Appendix A – Response to Submissions – SSD 9978934

Table 1 **Response to agency and authority submissions**

Figure 01 - Open Space Calculations

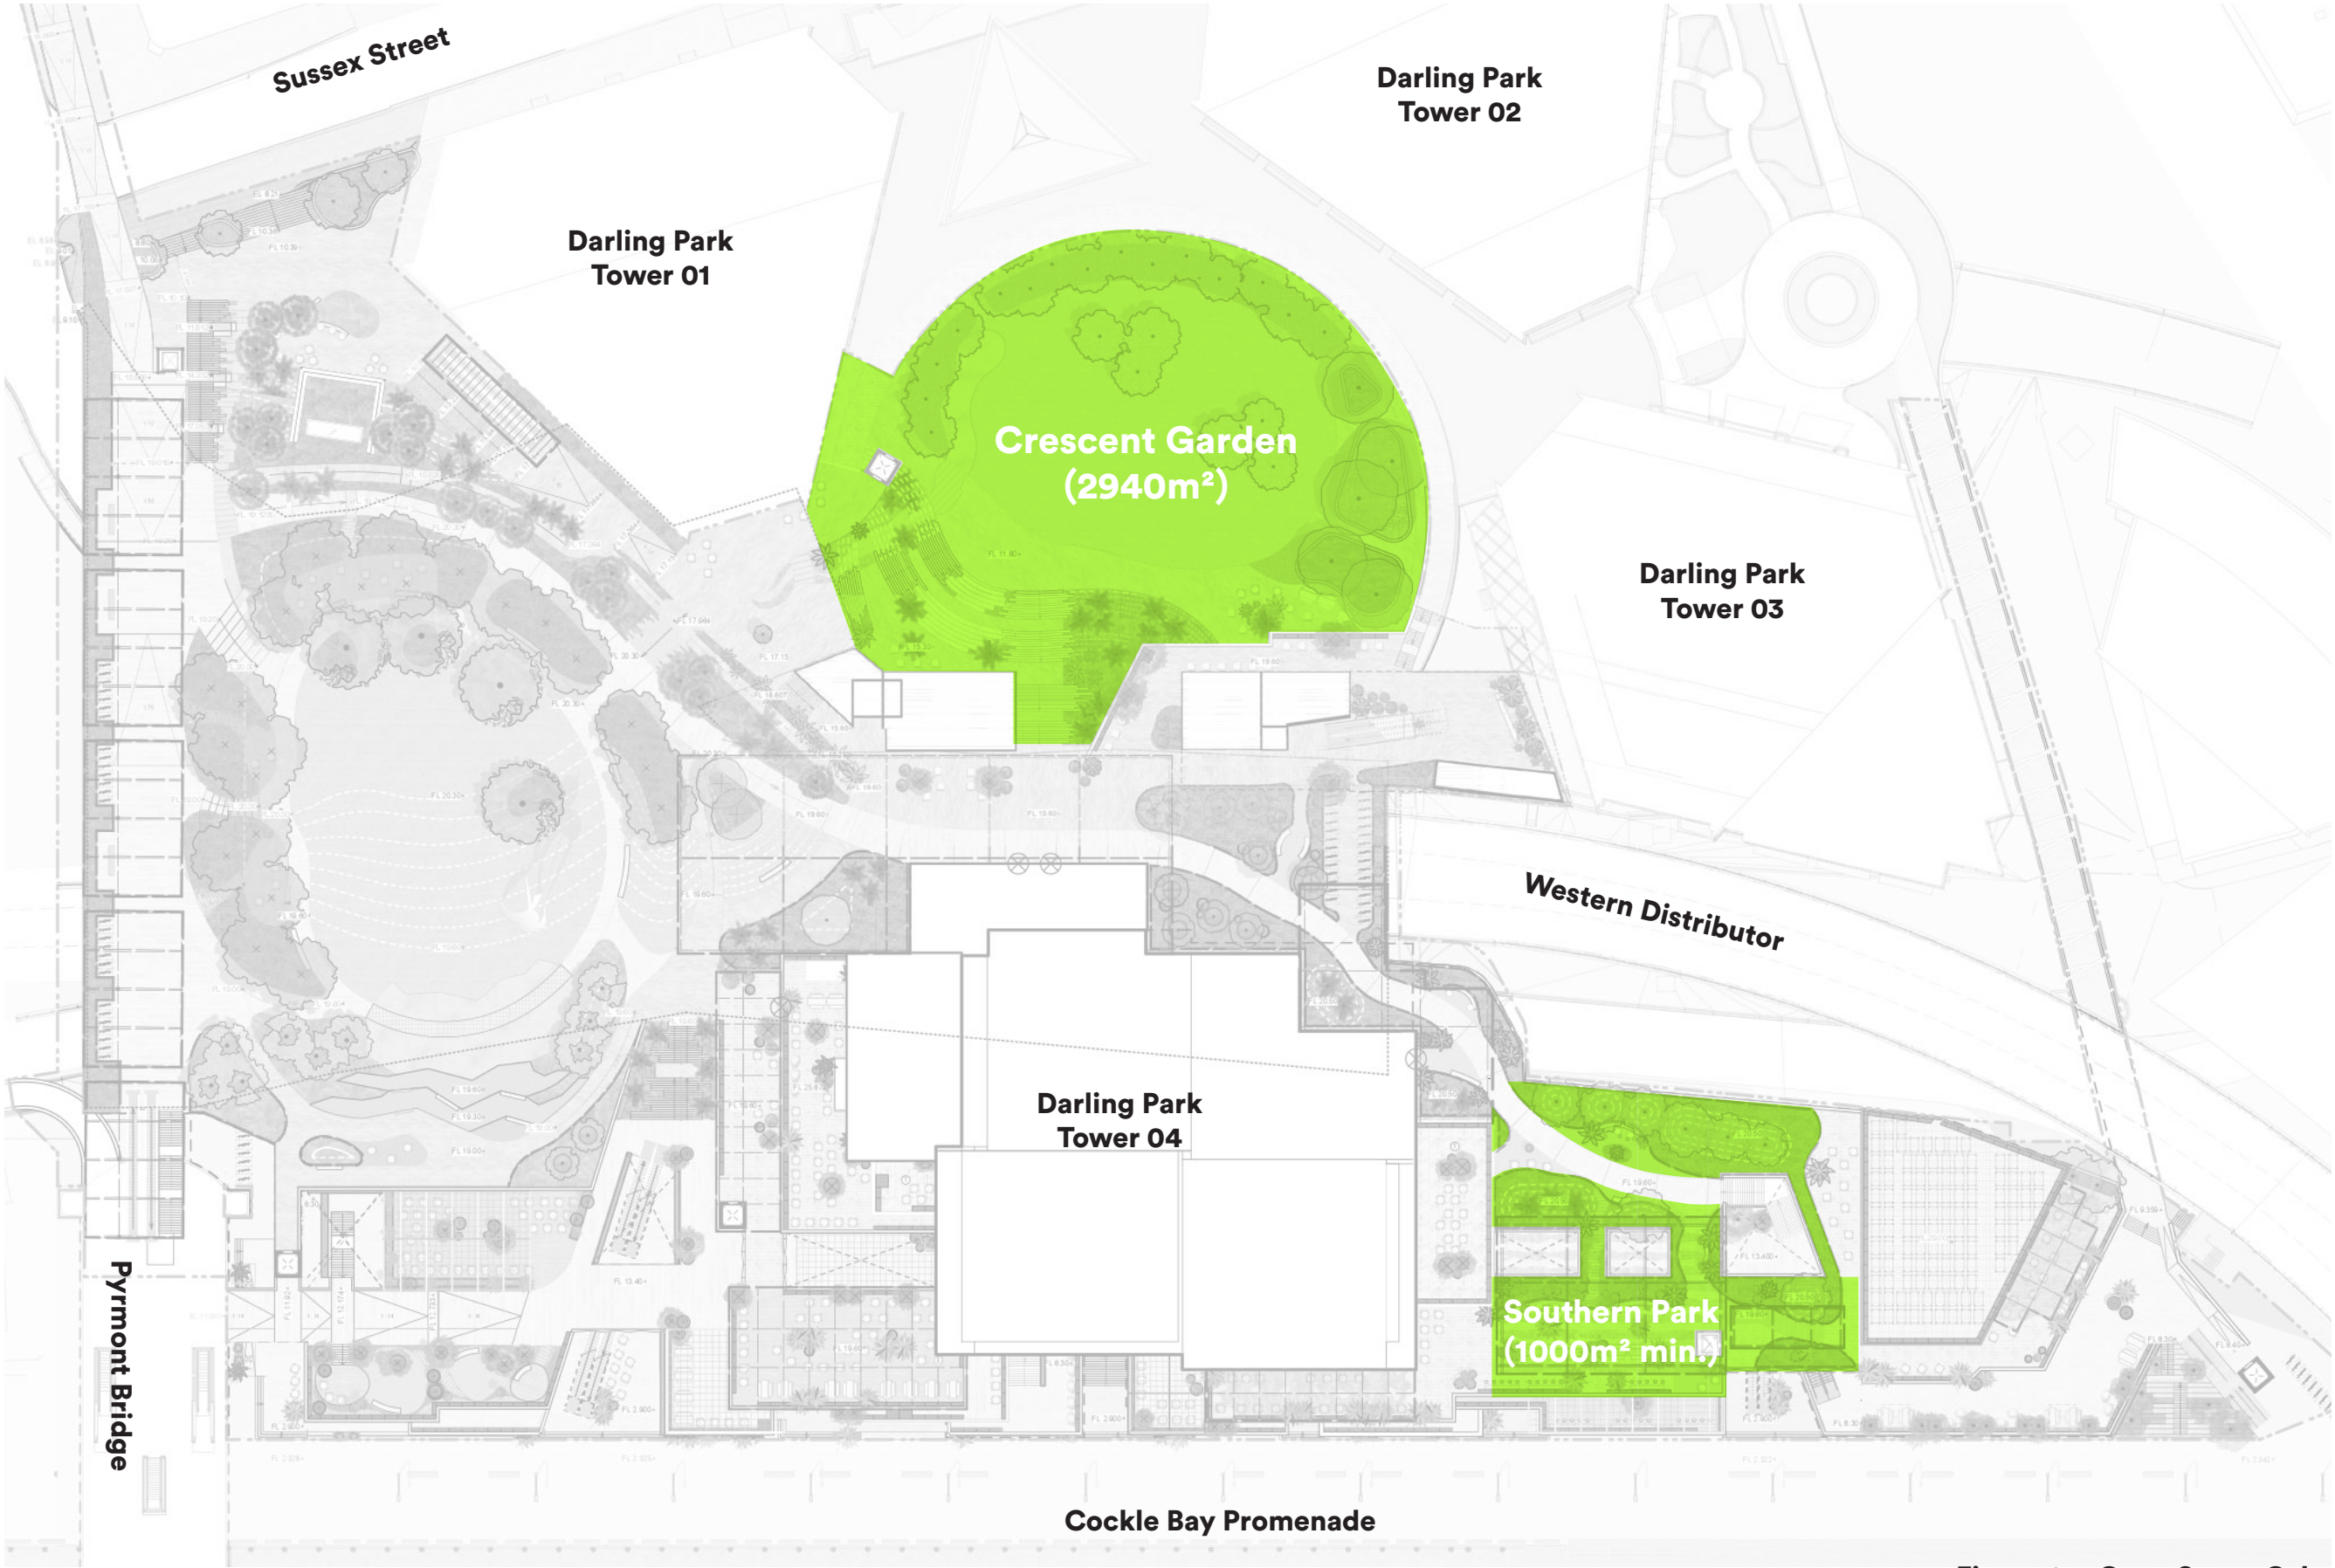
Landscape, Tree Management and Biodiversity		
COS11	<p>Calculations</p> <p>The areas of open space that are required for compliance with the Stage 1 DA vary in size between the landscape architect's calculations and the architect's calculations. For example:</p> <ul style="list-style-type: none"> Crescent Garden landscape drawings nominate 3078sqm while the architects nominate 2940sqm. Southern Park is required to be a minimum of 1000 sqm. The landscape drawings nominate 1325sqm and the architects nominate 850sqm. The open space calculations should be clarified prior to determination. 	<p>The updated calculations for the Crescent Garden and the Southern Park are detailed in Appendix H and clarified below:</p> <ul style="list-style-type: none"> Crescent Garden open space area is 2,940m². Southern Park open space area is 1000m² (minimum area.). <p>These areas meet the minimum requirement as set out in the ToA conditions A11 and A12, that the calculation of publicly accessible open space, shall exclude retail tenancies inclusive of outdoor seating/dining area and primary pedestrian thoroughfares for the principal purpose of access to/from and or through the development.</p>

PLAN - SIGHT DISTANCES - VEHICLE MERGING TO HARBOUR ST.
SCALE 1:100

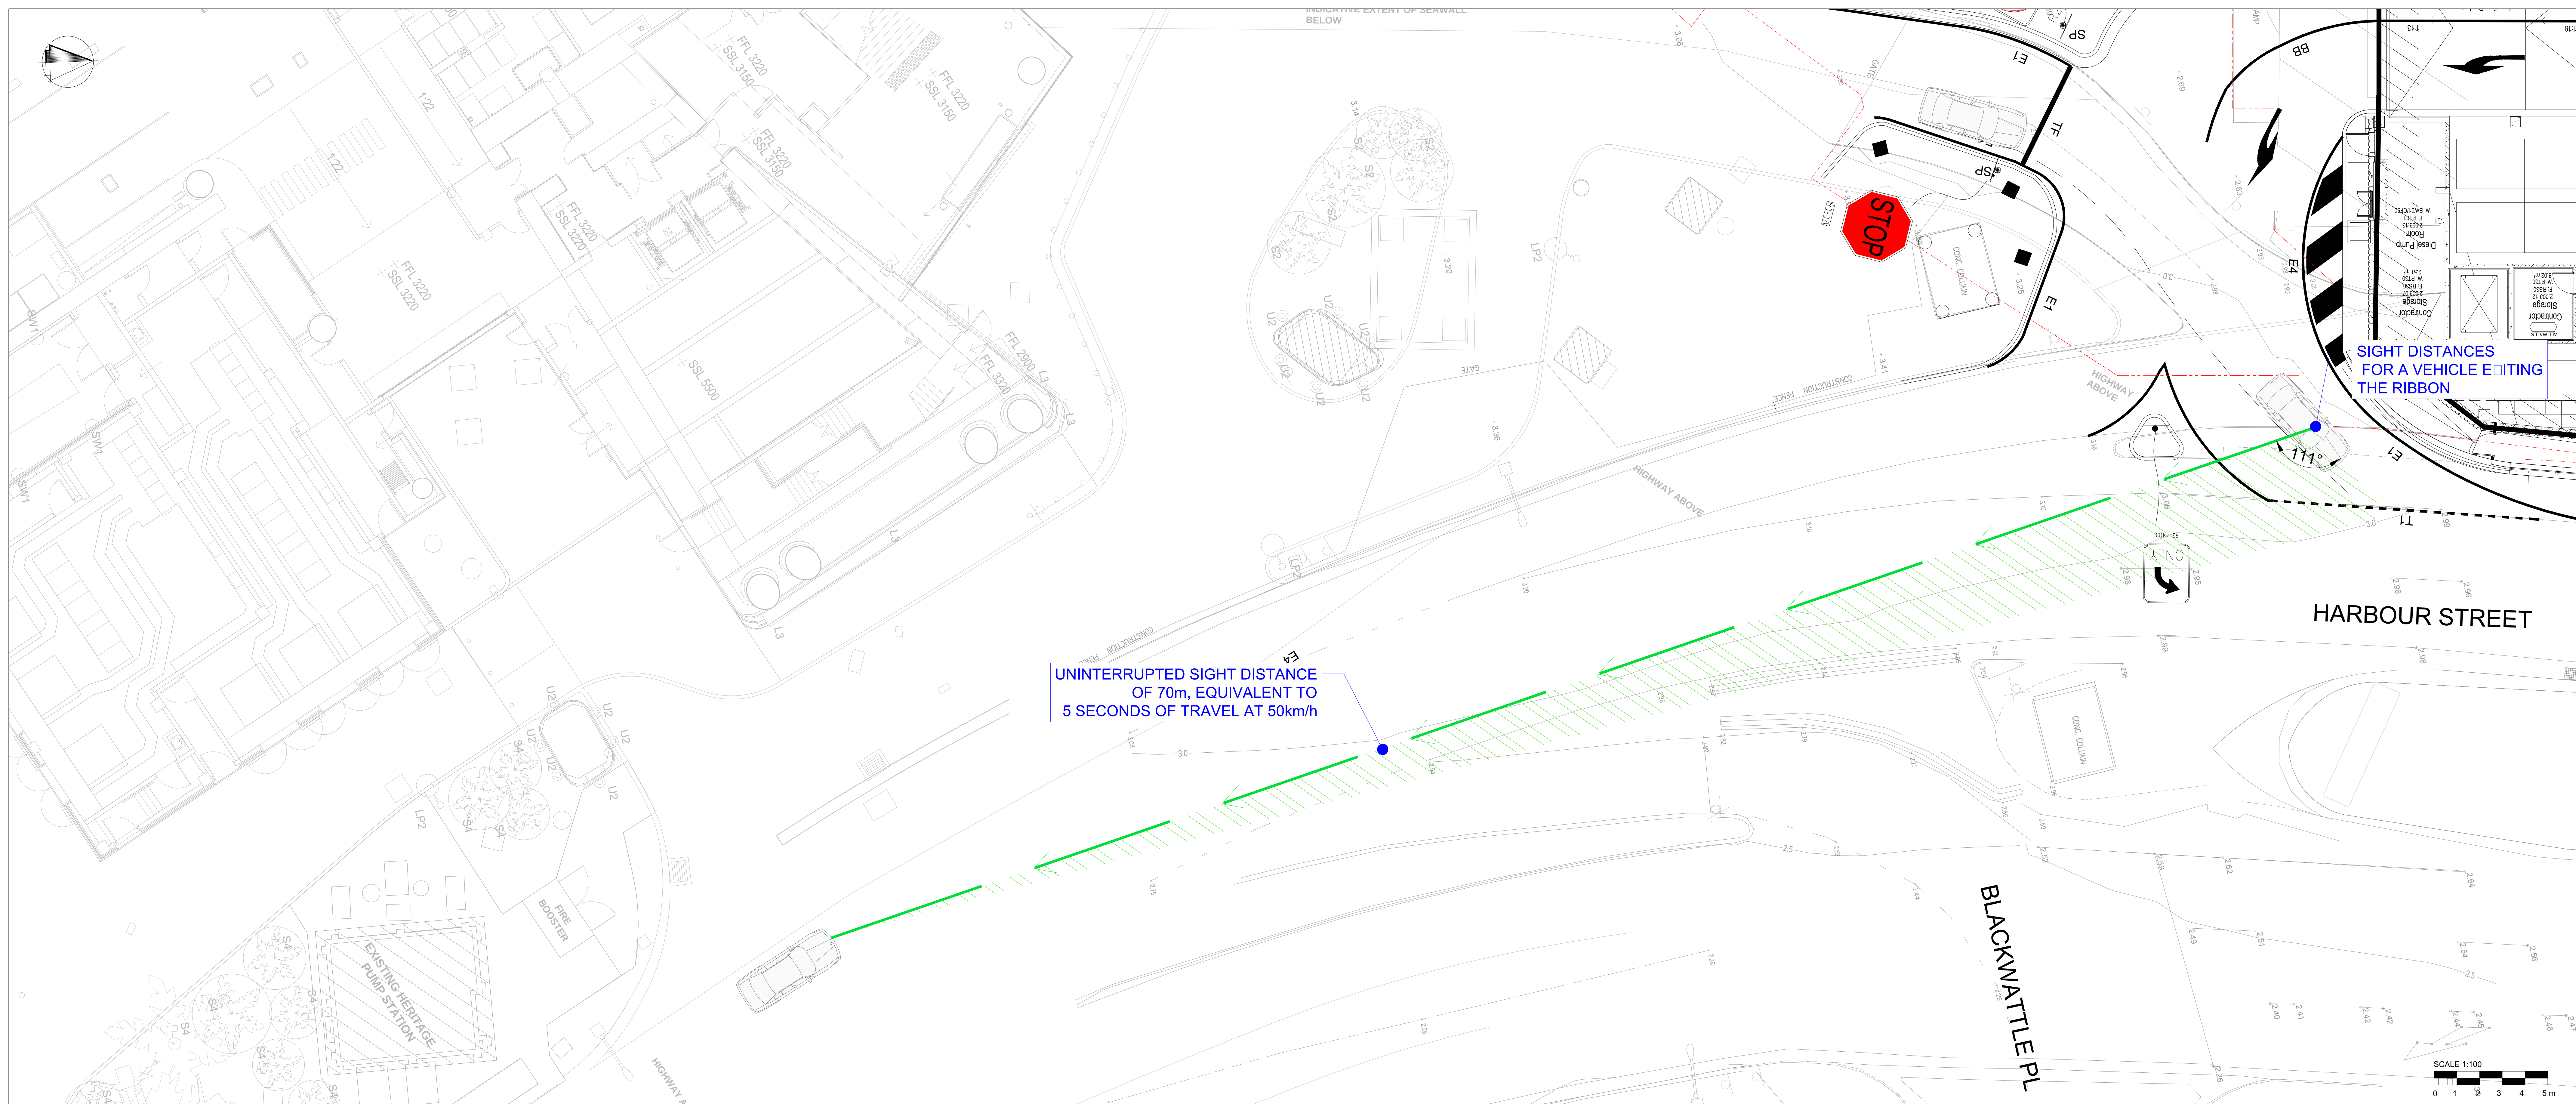
DPE7	<p><u>Traffic and Transport</u> Respond to Transport for NSW's (TfNSW) comments and information requests relating to:</p> <ul style="list-style-type: none"> a) Harbour Street access and road safety issues, including sight distances, swept path analysis and vehicle queuing impact b) porte cochere operational issues, including provision of PM peak demand data, overflow queuing and potential for bus/coach trip generation from retail and public domain spaces c) active transport/bicycle enhancements (waiting queuing areas, wayfinding, ramps, stairs and lift access). 	<p>In relation to the Harbour Street access and road safety issues raised, revised swept paths and site distances have been provided at Appendix M.</p> <p>In relation to the operation of the porte cochere, these items have been addressed in the Aurecon letter at Appendix E. Revised Wheat Road and Public Domain Alignment Plans have also been provided at Appendix P.</p> <p>In relation to the active transport items, these have been addressed in the TfNSW responses in this table, see items TFNSW 12 and TFNSW 13.</p>

drawing
**GA - Tower Low Rise - Level 05,
Crescent Garden - Level CG-05**

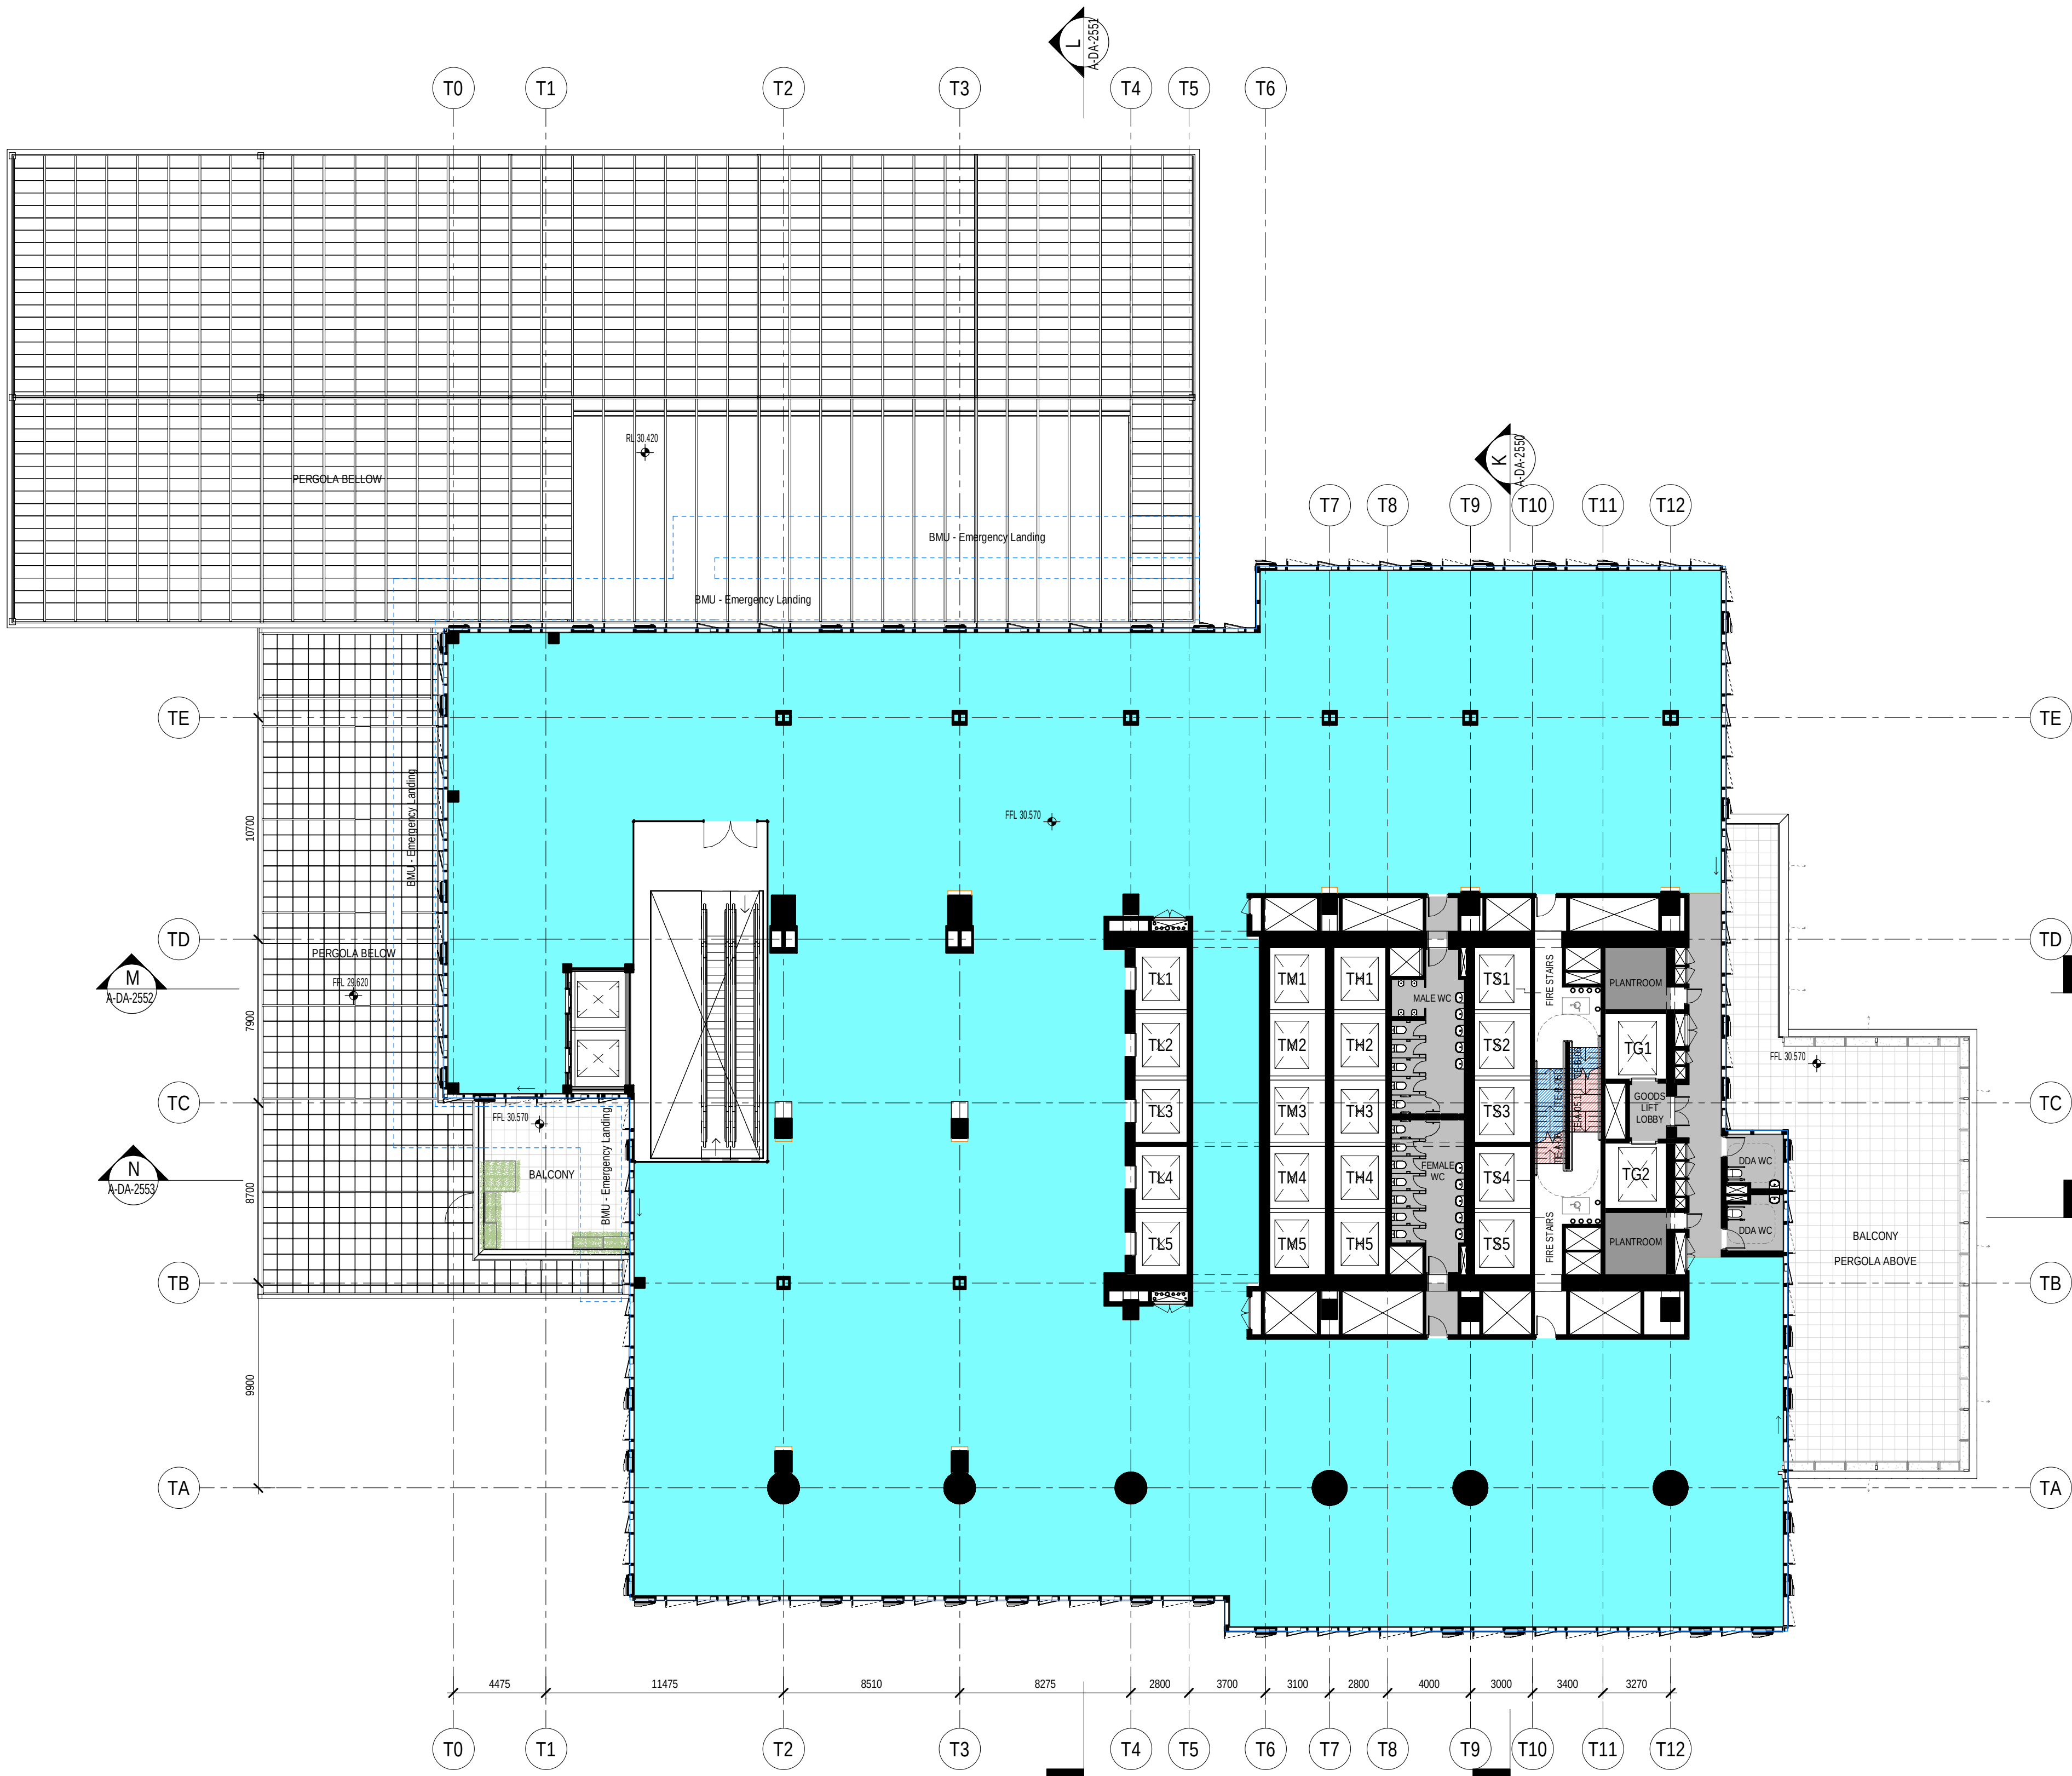
DPE19	Update the drawings and waste management plan to address Council's information requirements.	This is responded to in the City of Sydney section in the following sections of this table.
DPE20	The SSD drawings include two plans with identical references and titles (drawing A-DA-1090, p14 and p15 of Appendix A1). Confirm whether approval is sought for both drawings, and if so, update the drawings to provide individual references and titles	The drawings have been revised and page 15 has been omitted. Please refer to Appendix B .
Environment and Heritage Group		
EHG1	Environment and Heritage Group (EHG) raised no biodiversity or flooding concerns, but recommended consultation with the NSW State Emergency Service in relation to flood and evacuation. EHG understands that this consultation has occurred and thus has no further comments.	Noted.
Department of Planning and Environment: Water		
DPEW1	1.0 Water Access Licence 1.1 Recommendation – Post Approval That the proponent ensures: <ul style="list-style-type: none"> sufficient water entitlement is held in a water access licence/s to account for the maximum predicted take for each water source prior to take occurring unless an exemption applies. 	Noted. The Proponent accepts a condition of this nature.
